Re. Revised planning application at 3 Central Ave.
Rustington - R/255/14/HH

I note that having obtained permission for a new flat roofed extension to the rear (south side) of this totally revamped property, the applicant has now asked for permission to change this to a part pitched roof, no doubt for cosmetic reasons, to which I object.

Elevations (1:100)

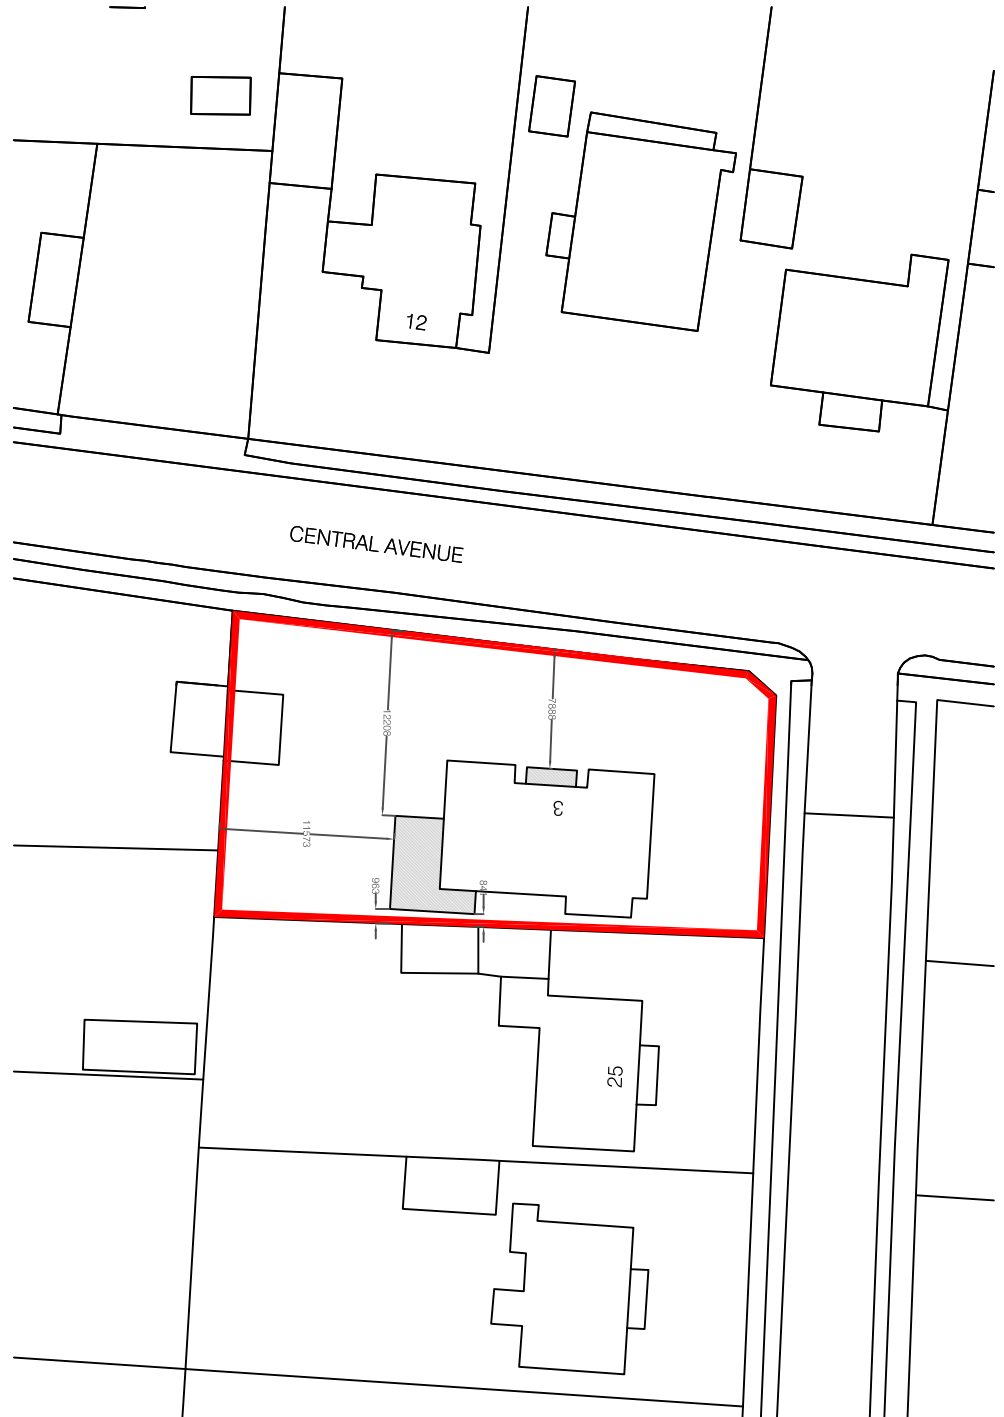
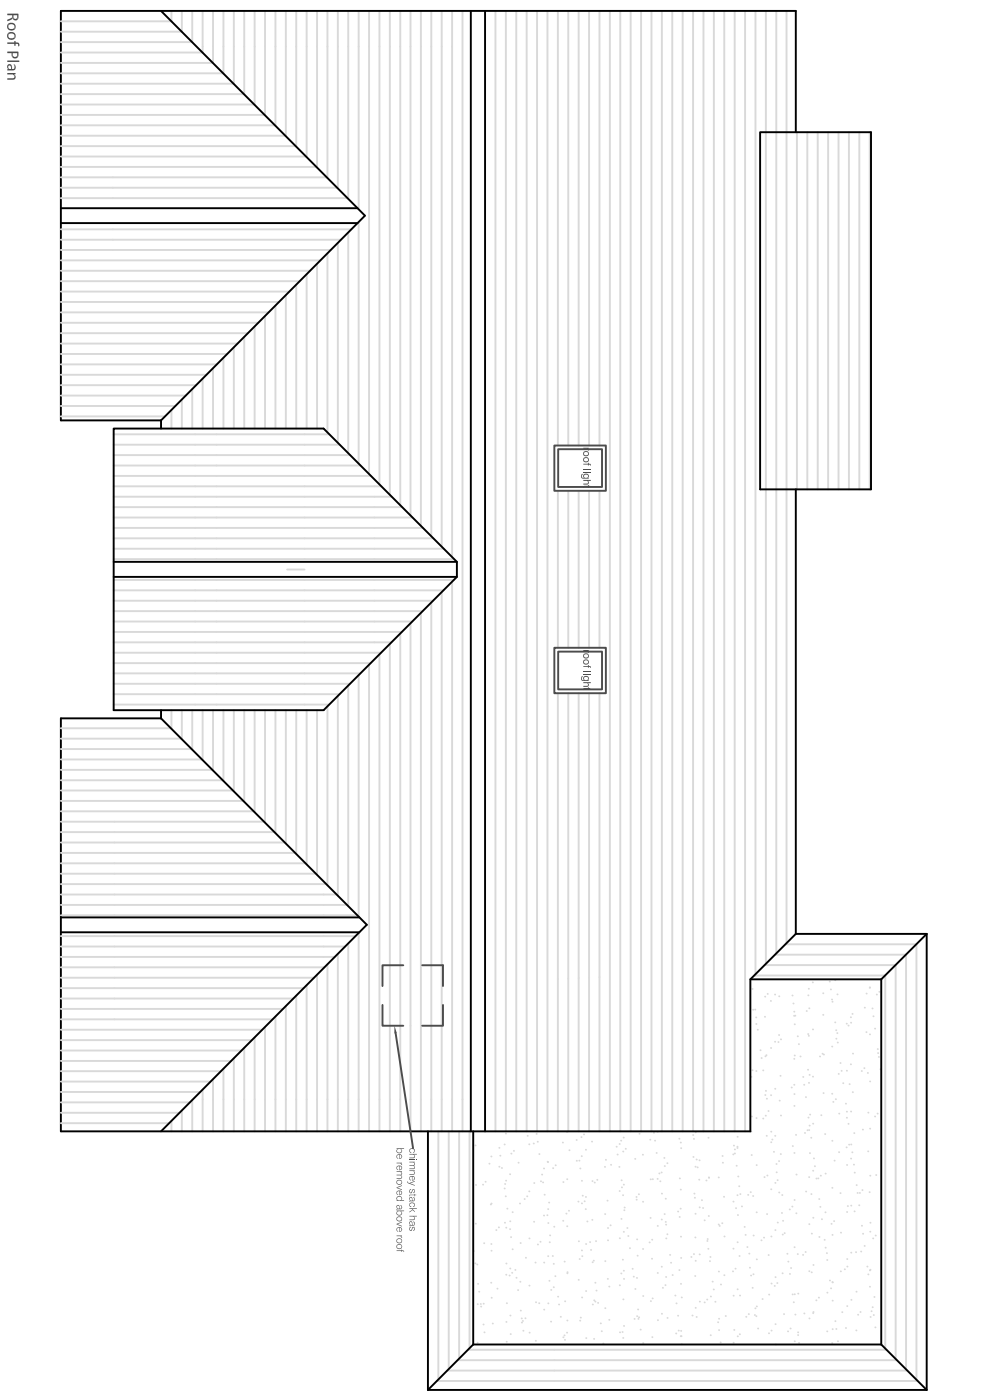
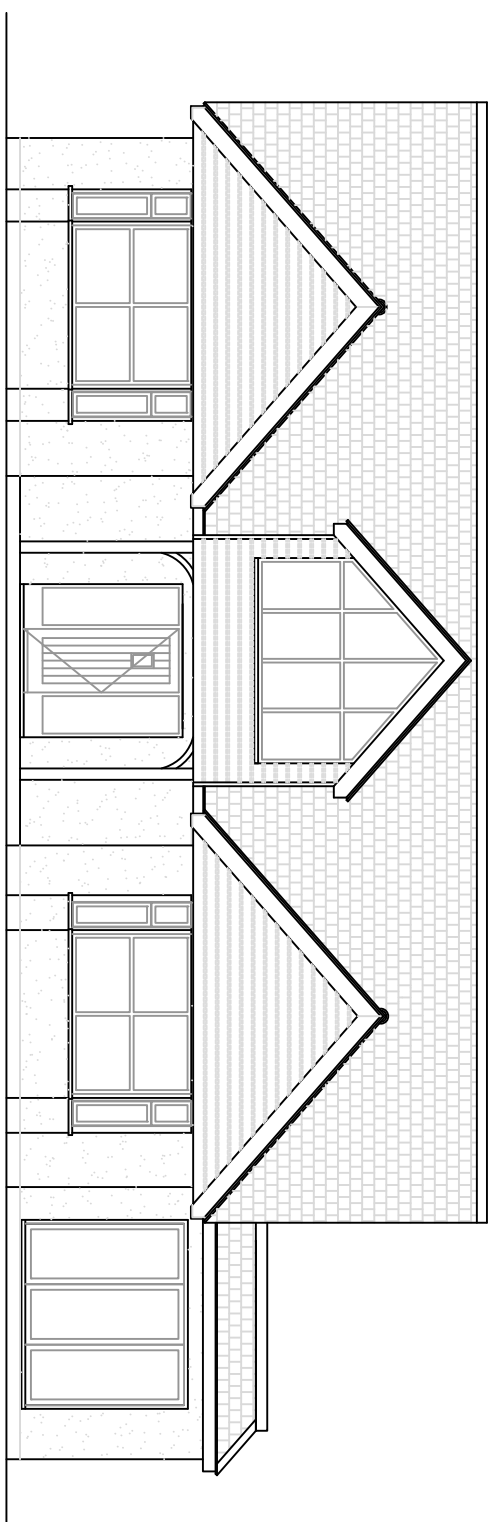
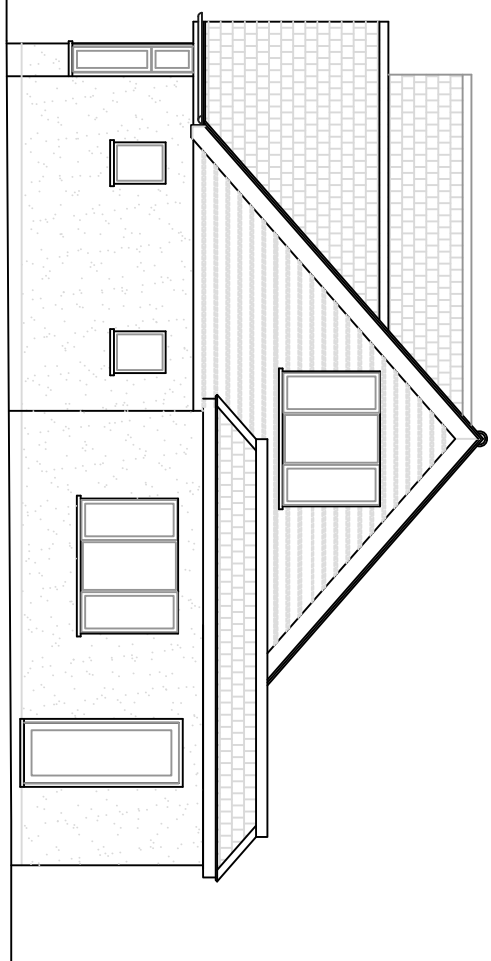
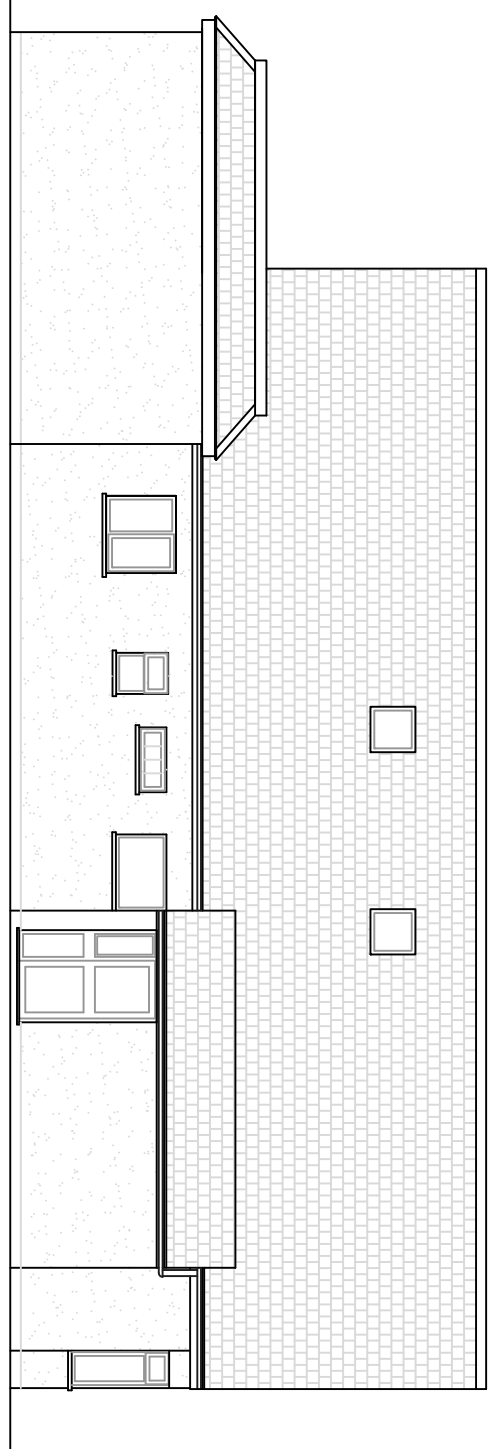
although no objection to the original plans were made the resulting size of the rear extension is much larger than imagined and being only 18 inches from my fence, will definitely screen afternoon sun, from the west, from my own and my neighbours garden.

If this new additional height of a surrounding pitched roof is allowed, more light & sun will undoubtedly be lost.
